Date: 03 February 2021  
Our ref: 341967  
Your ref: 3/2020/0667

**Planning consultation: Change of use and conversion of former fish hatchery to three holiday let units and creation of associated car park for six vehicles.  
Location: Whitcher Well Fish Hatchery Whitendale Road Dunsop Bridge BB7 3BL**

Following our previous consultation response, we have reviewed the amended plans and reports submitted and have the following comments to make.

LANDSCAPE MASTERPLAN

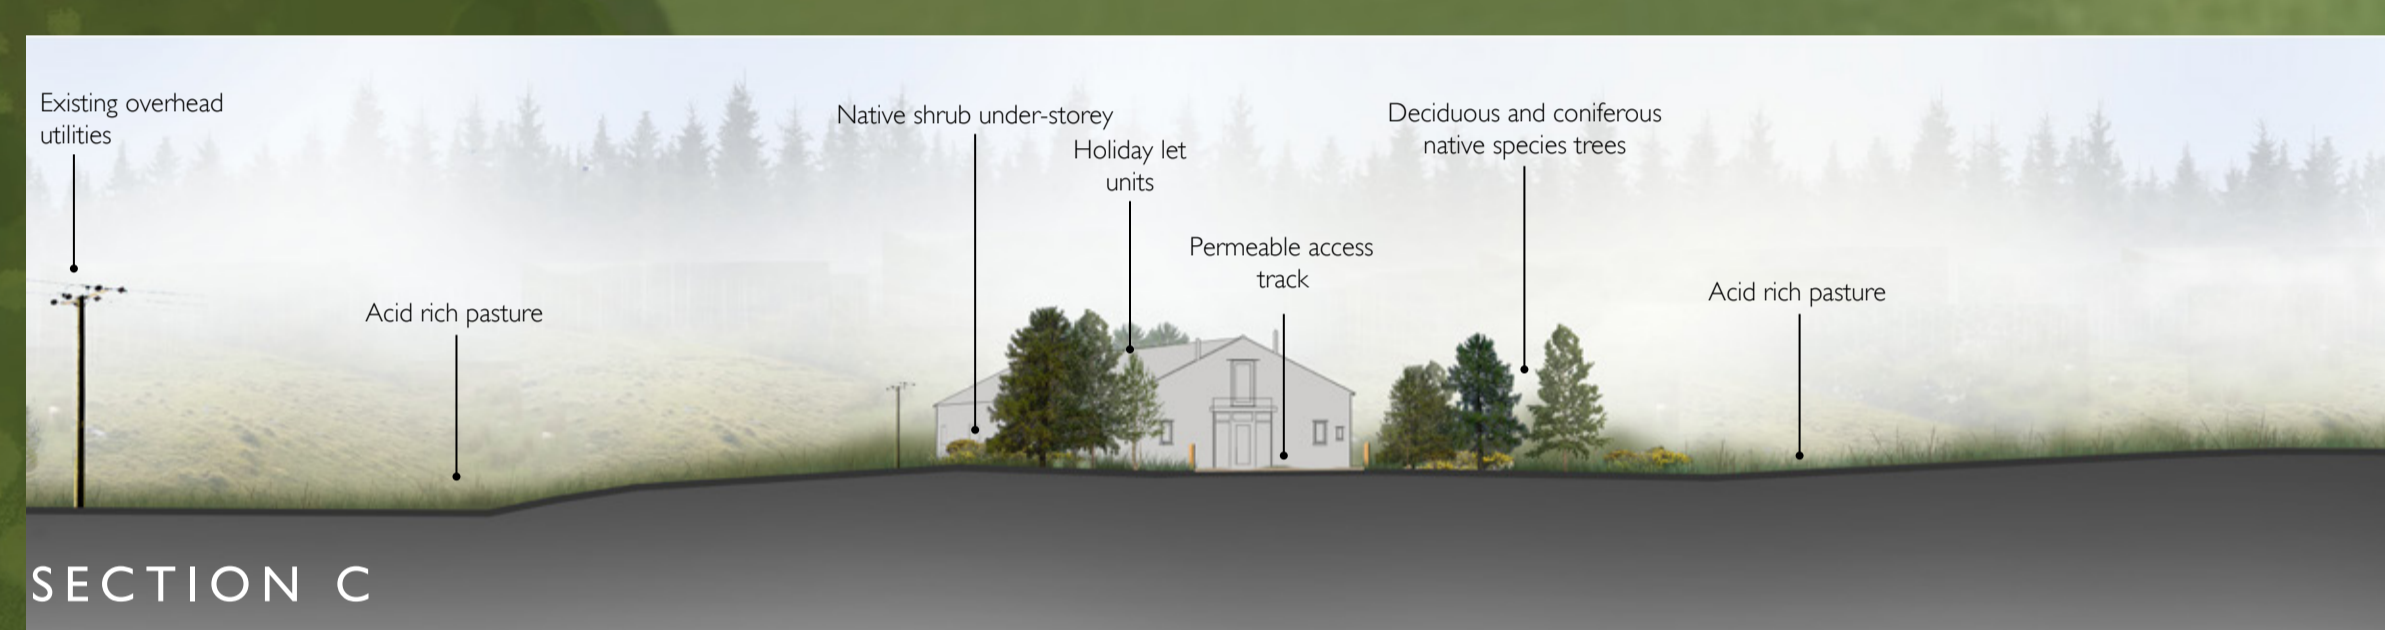
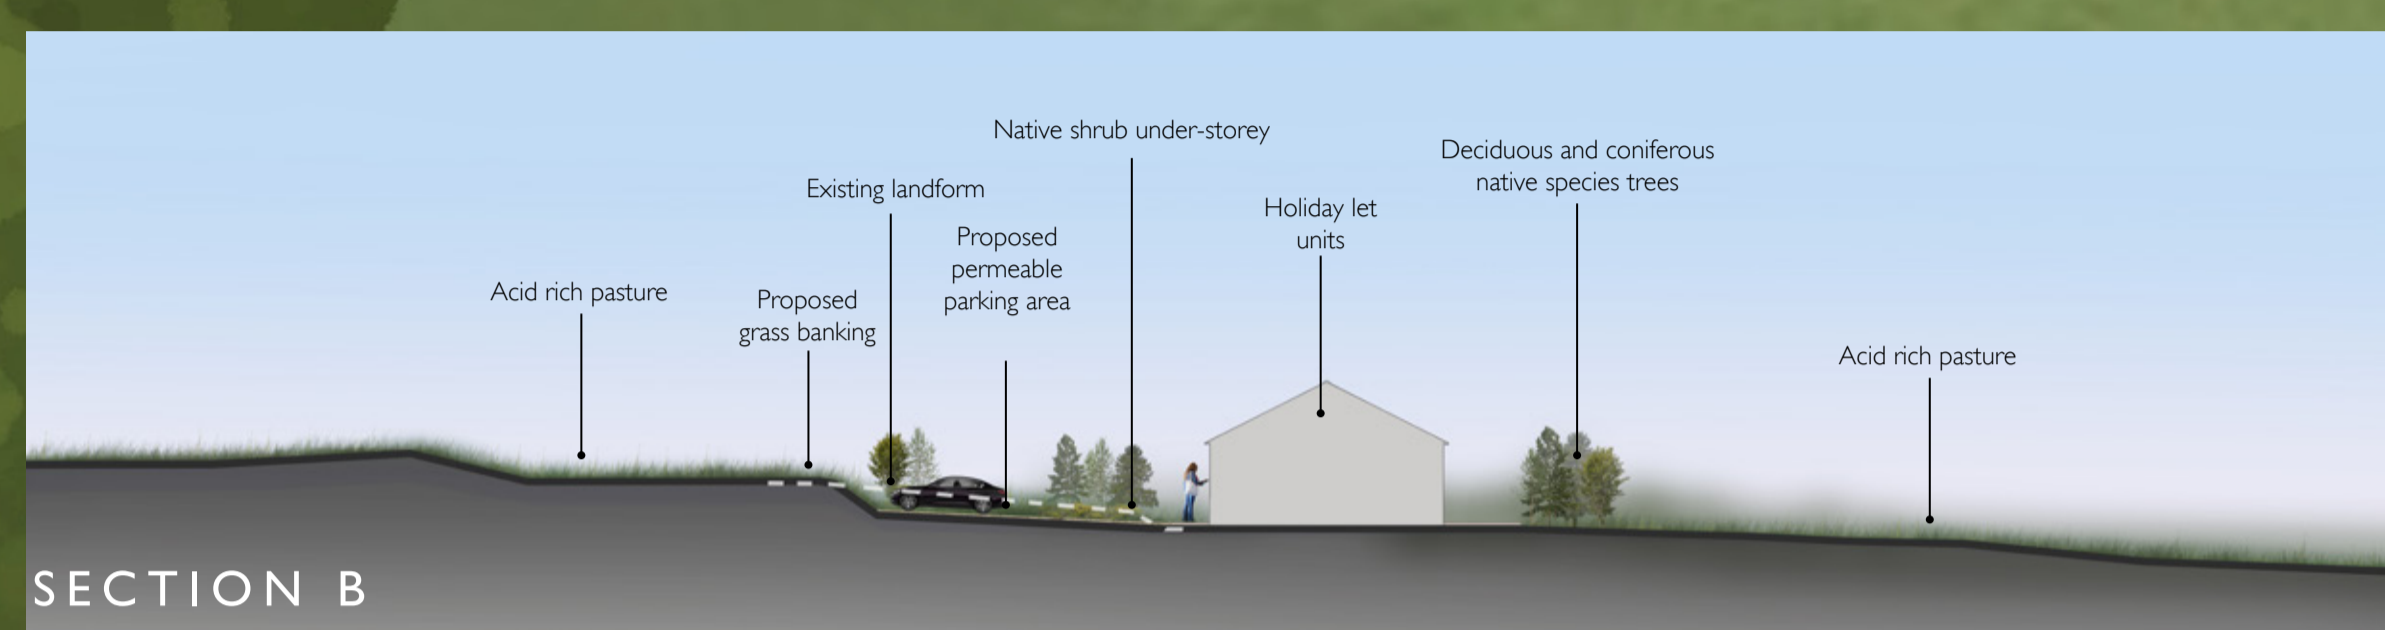
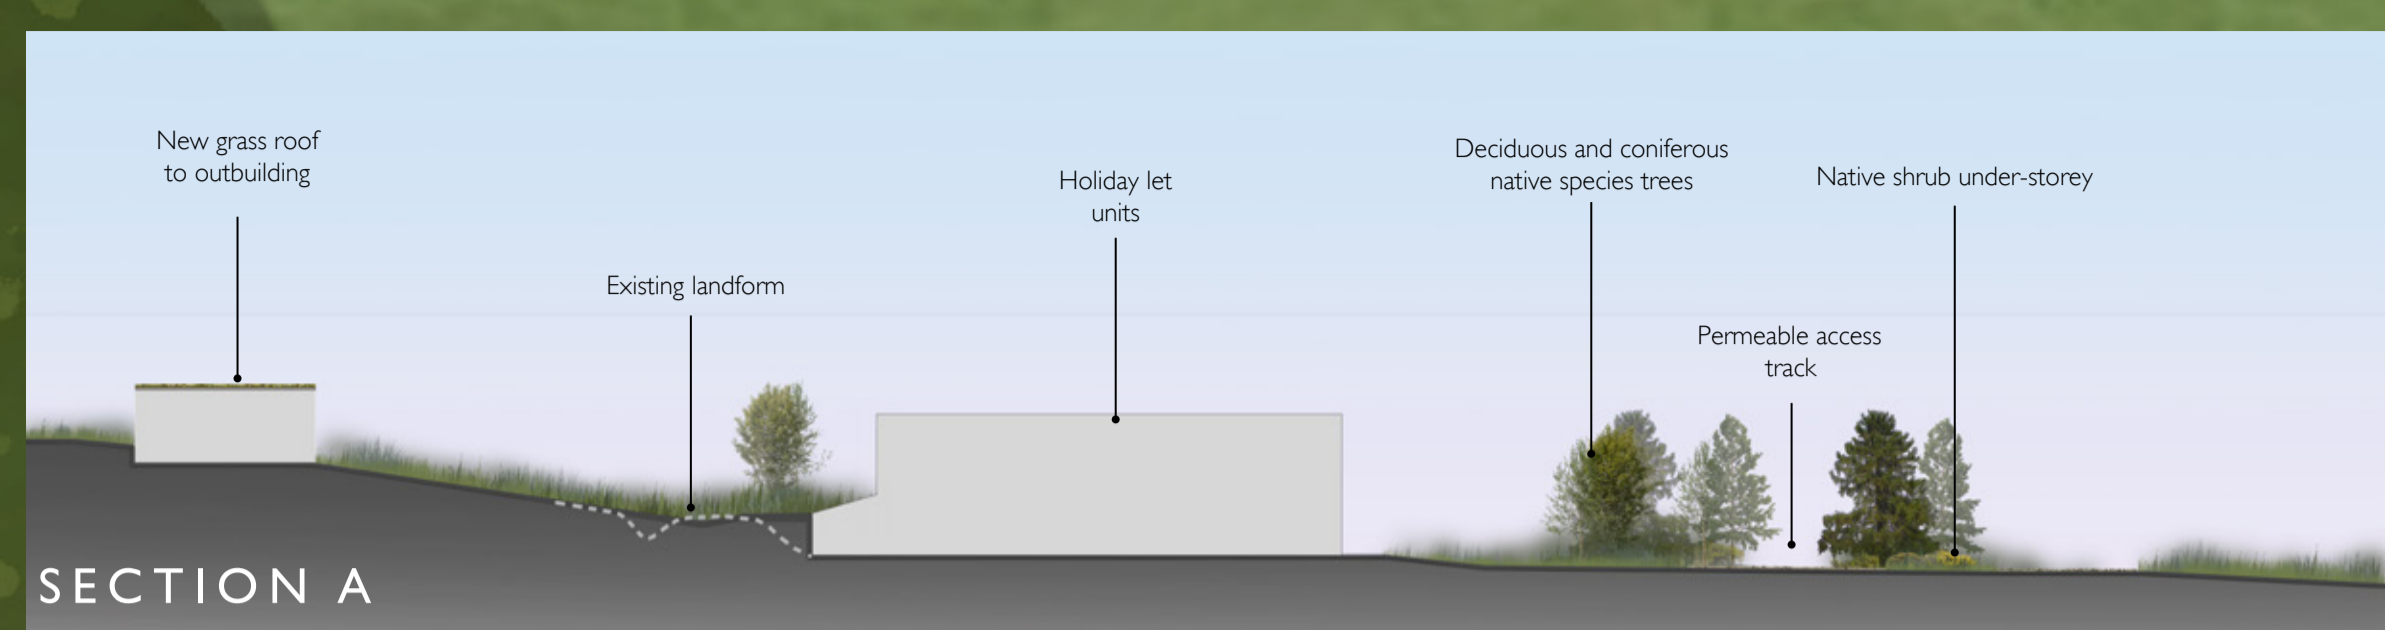
We have reviewed the amended Summary Landscape and Visual Impact Assessment (LVIA) (Rural Solutions, May 2019, Rev A), the Landscape Masterplan and Elevations and Typical Section as Proposed (5891 c/b/02 Rev B). We are satisfied that the proposed amendments to the elevations of the building, screening and lighting arrangements overcome our previous concerns we are confident that you now have the information you need to reach a fully informed decision.
